PLANNING AMENDMENT

Application No. 409/0101/96
Date Registered 13 MAR 1996
Case Officer DG

NORTH PARADE, HOLBEACH, SPALDING, LINDS, PE12

NEW DWELLING

PROPOSED NEW DWELLING AT
NORTH PARADE, HOLBEACH FOR
MR & MRS B. CAVE

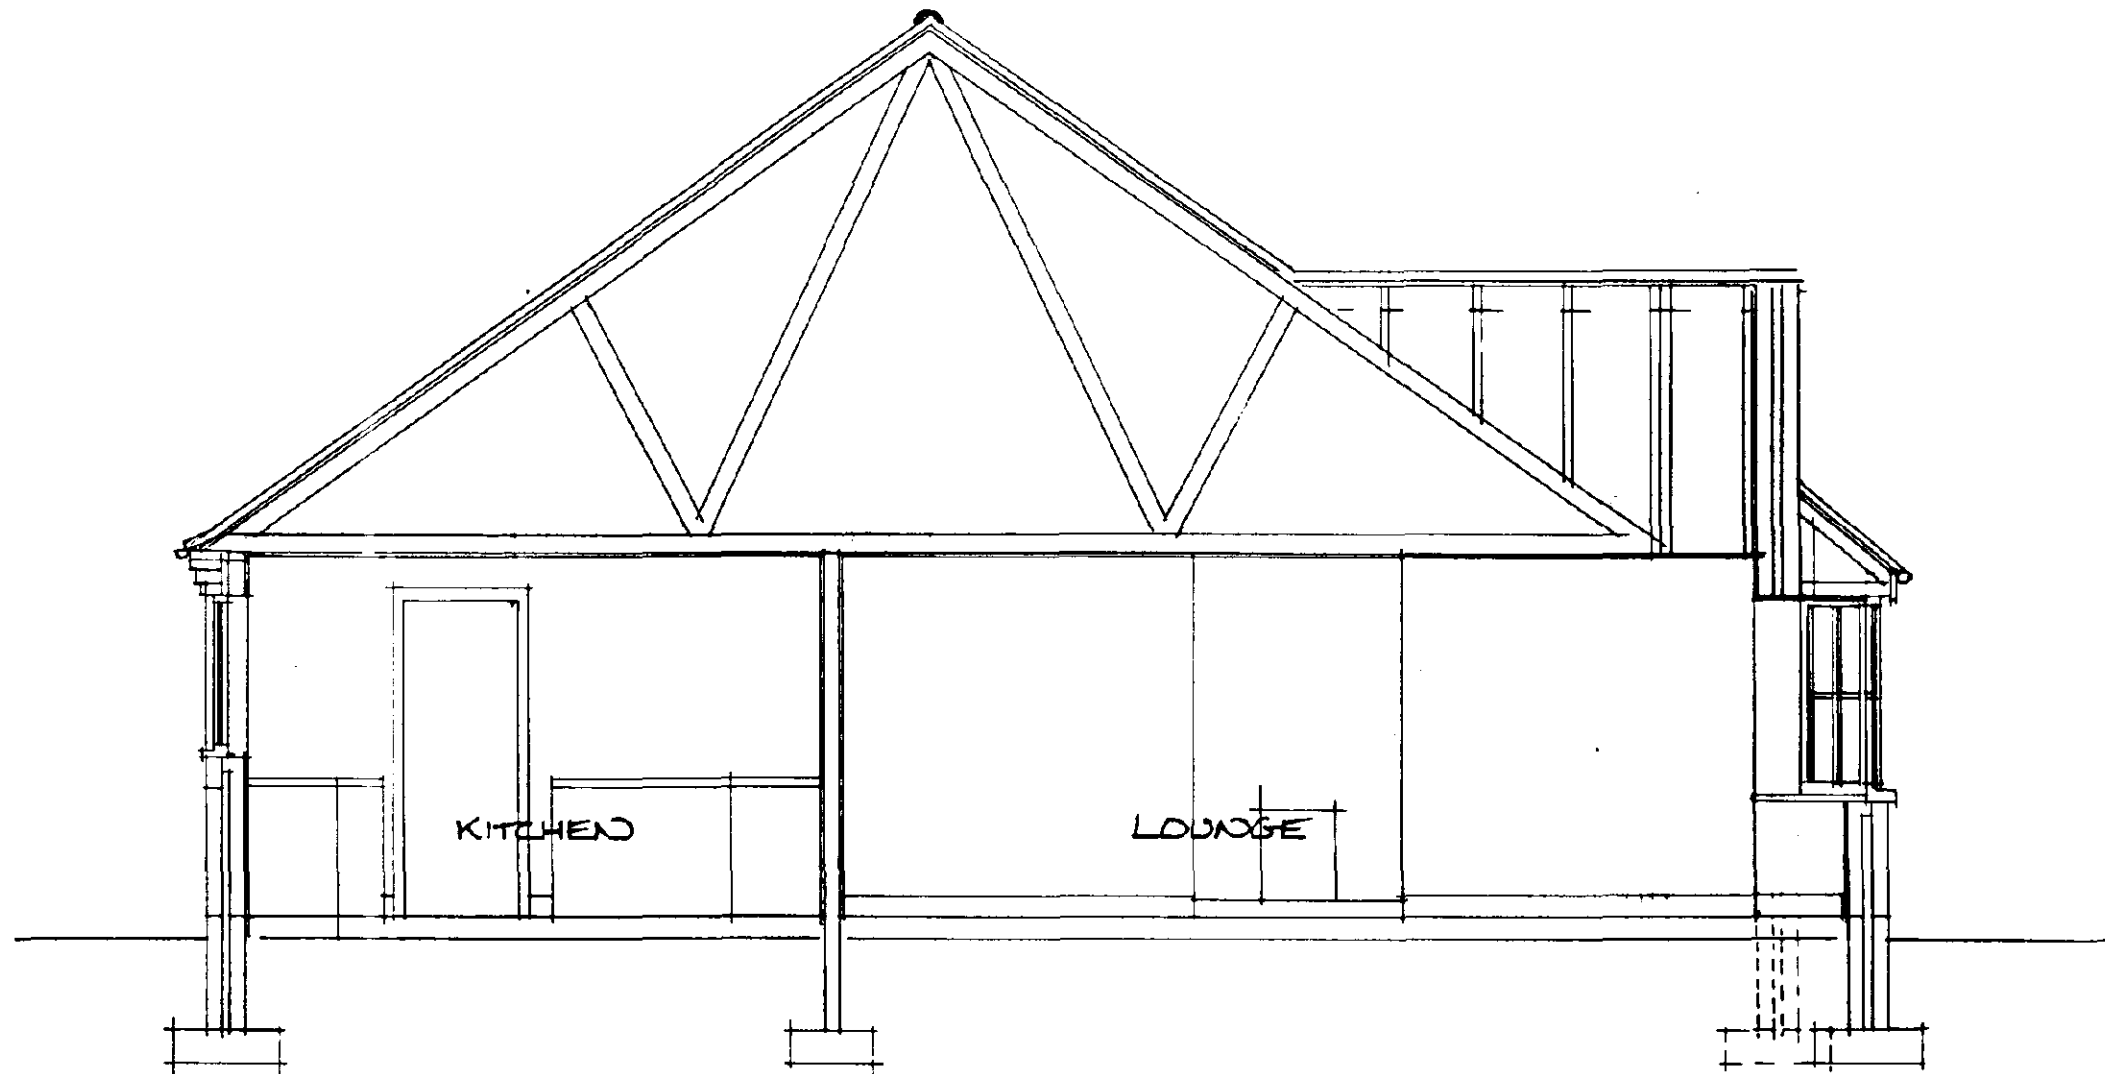
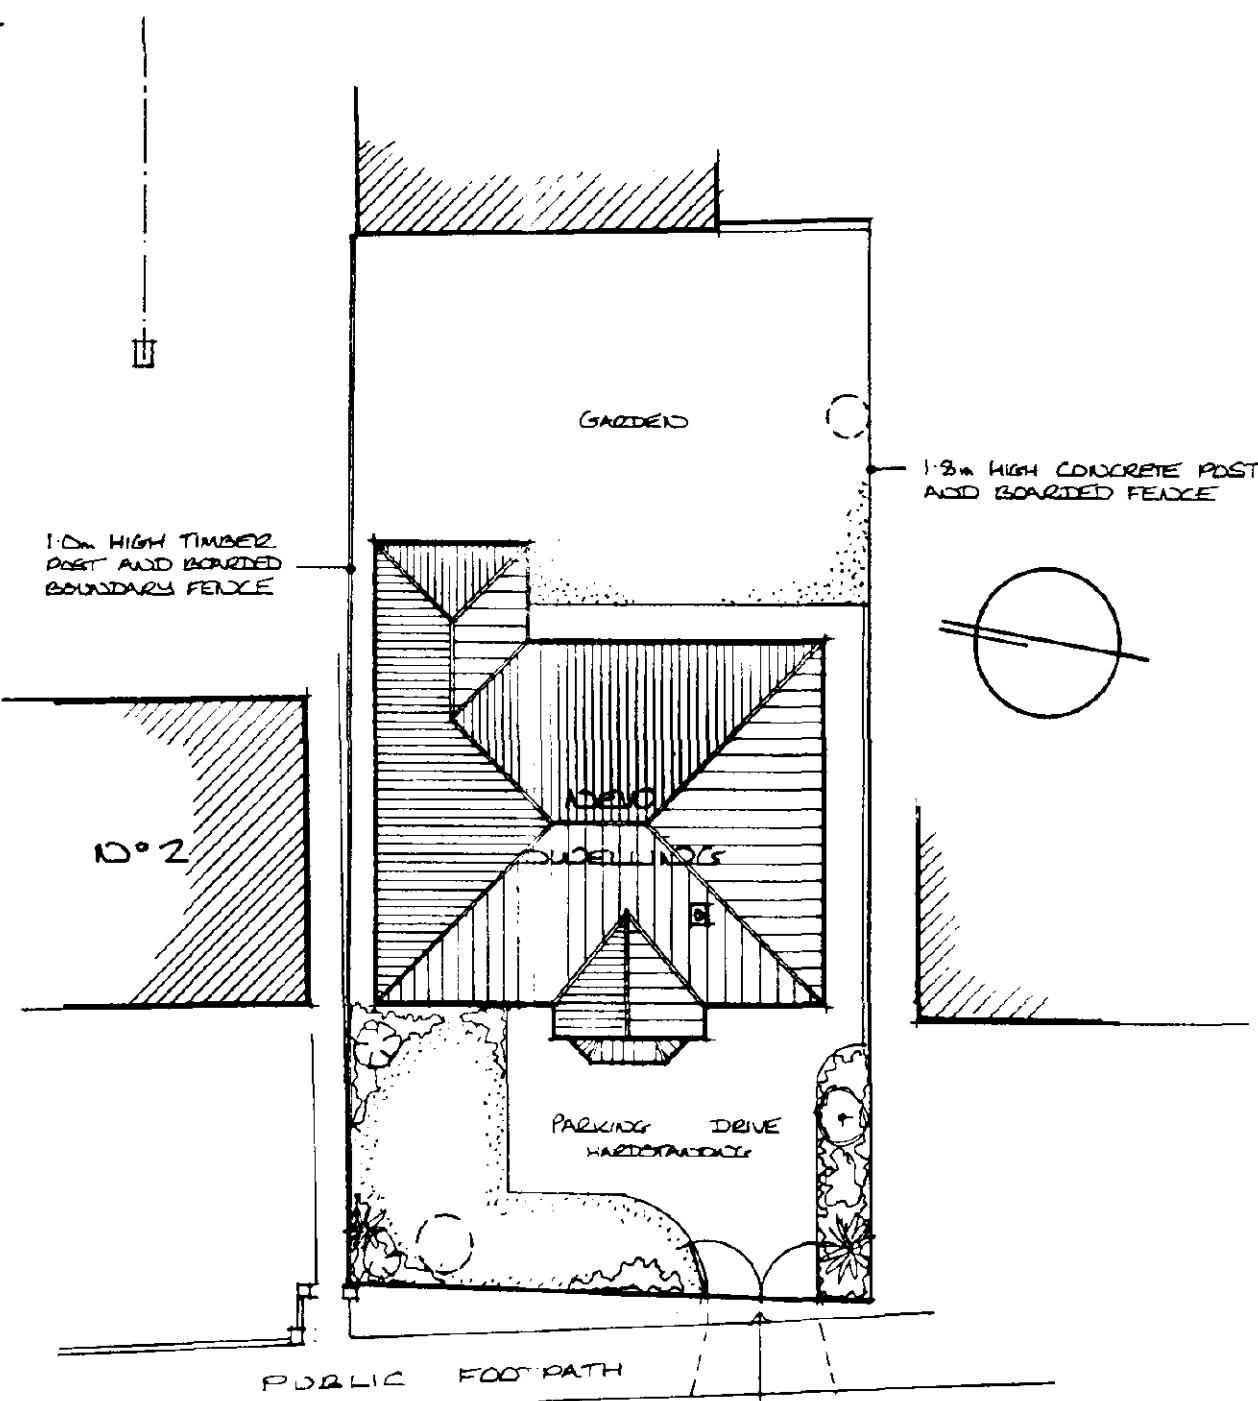
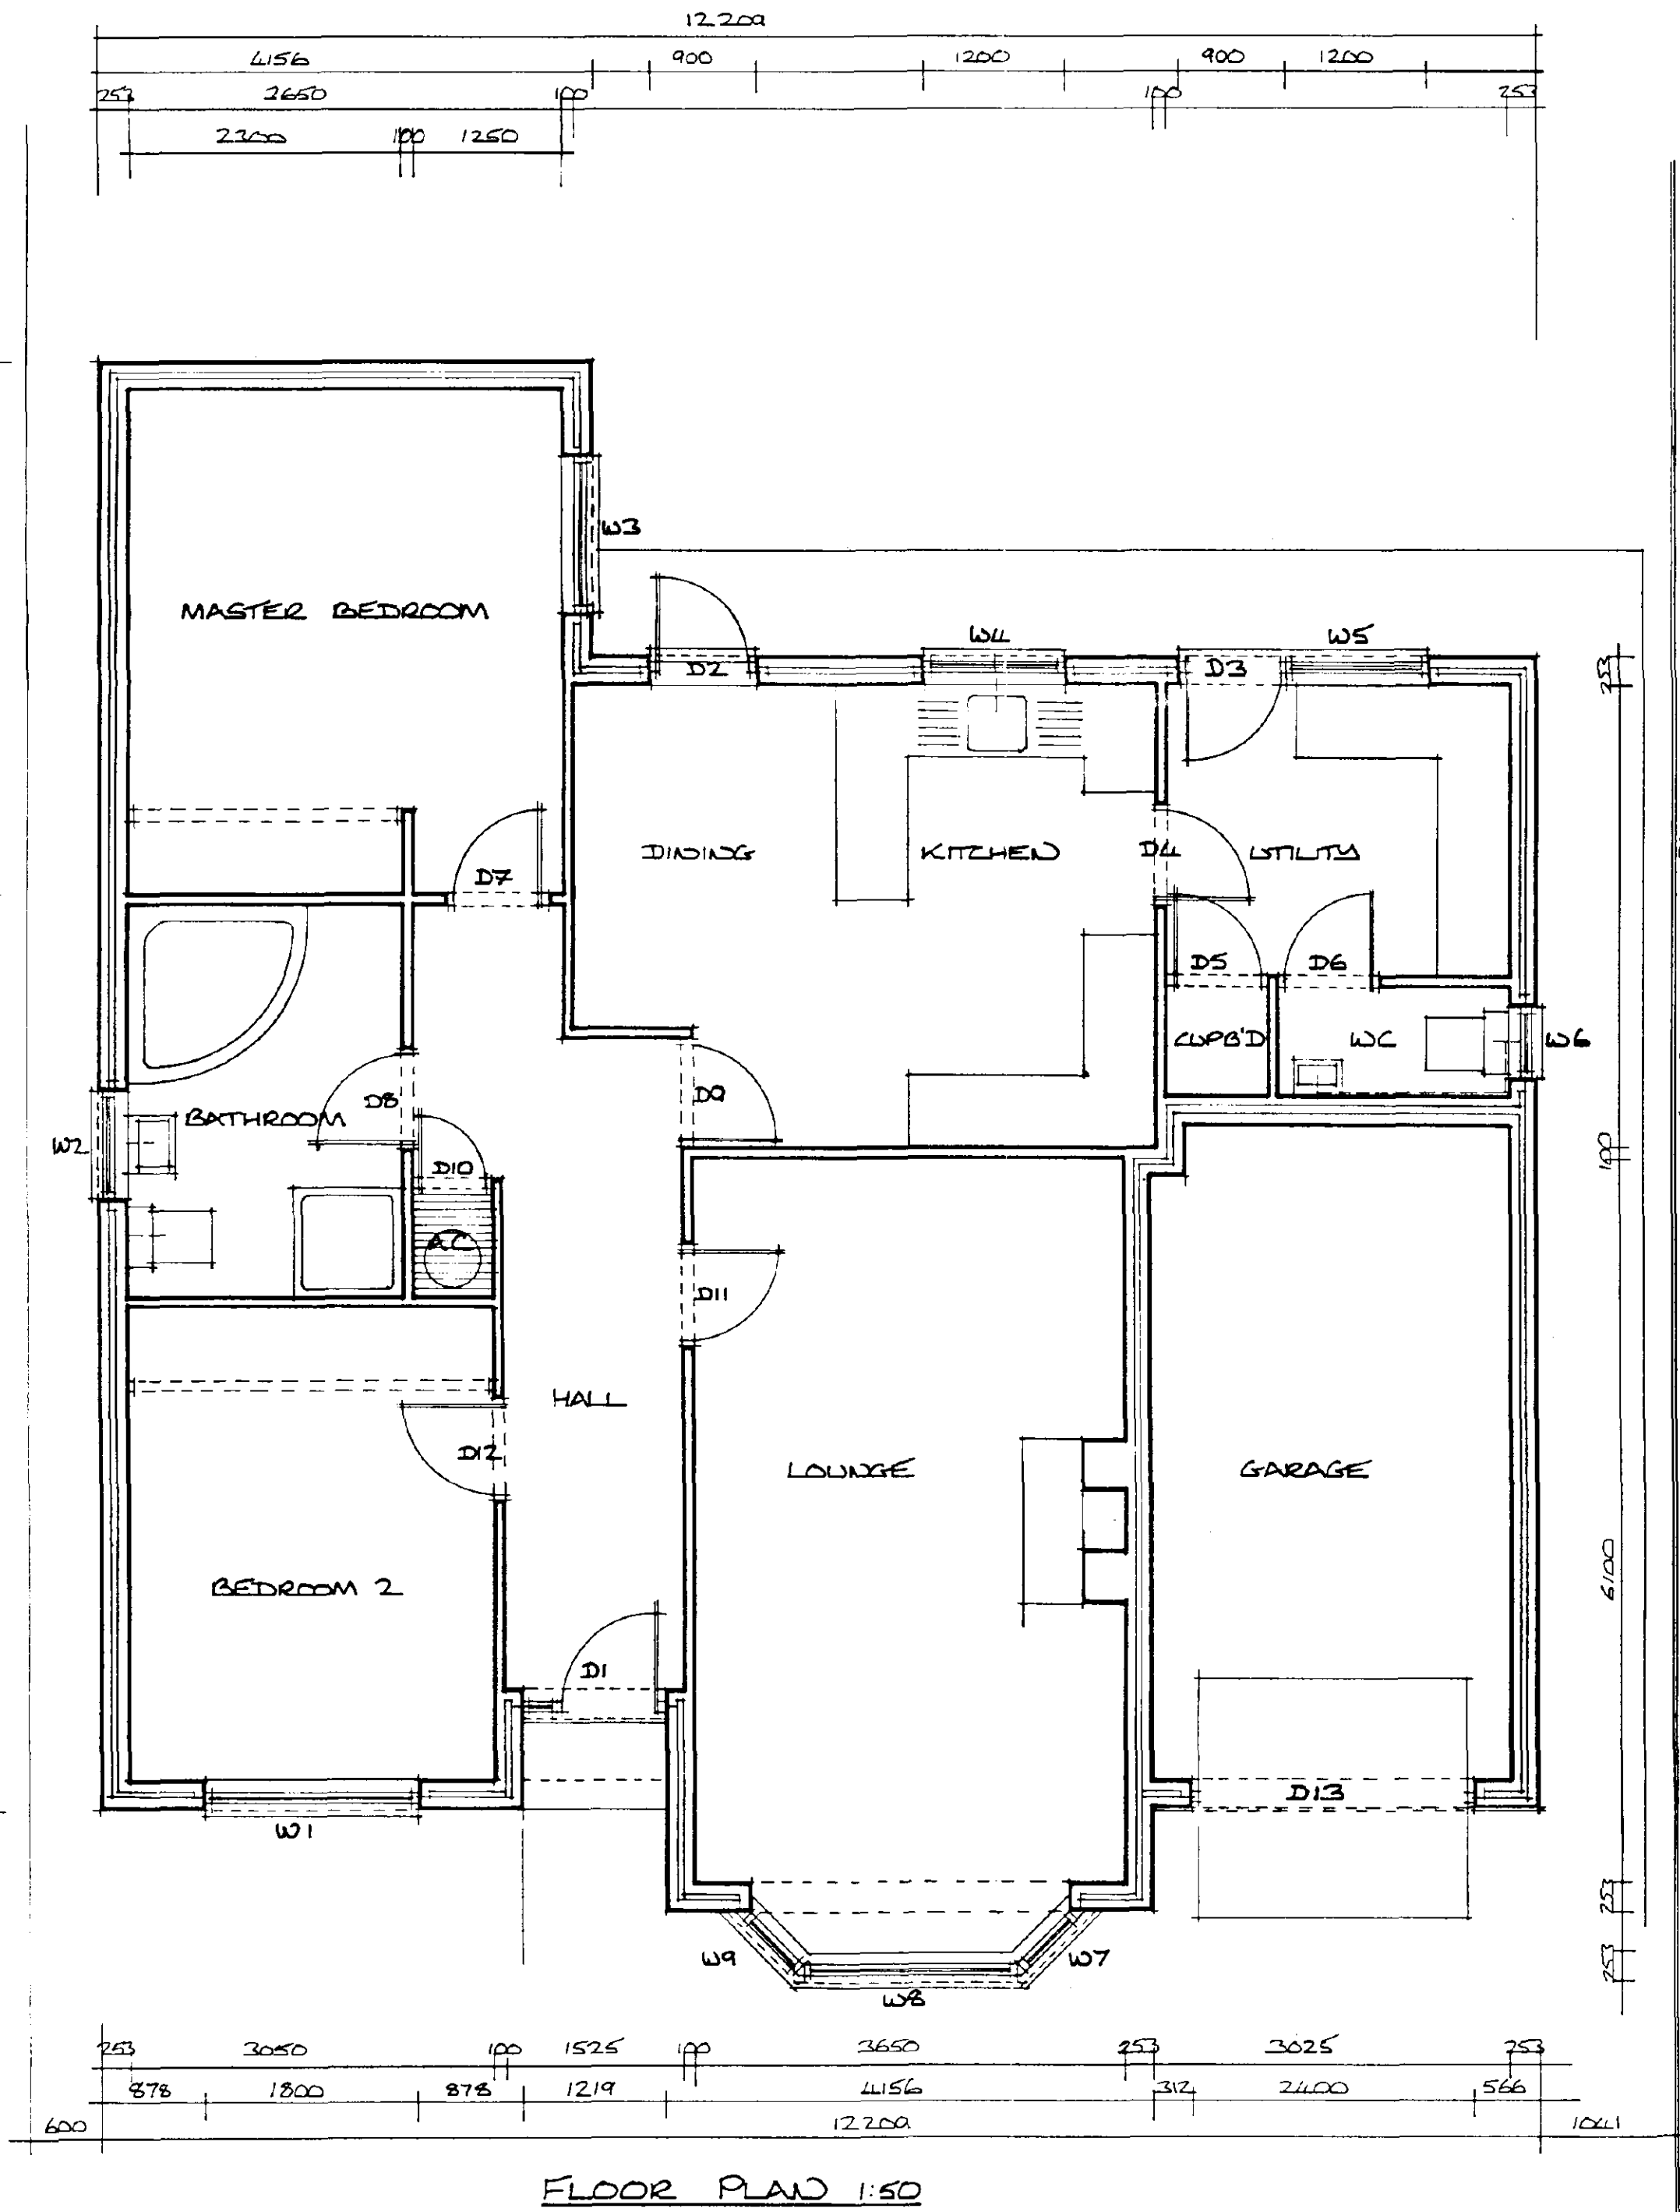
WHITE UPVC FACIA AMENDED TO BRICK DETAIL 'FACIA'
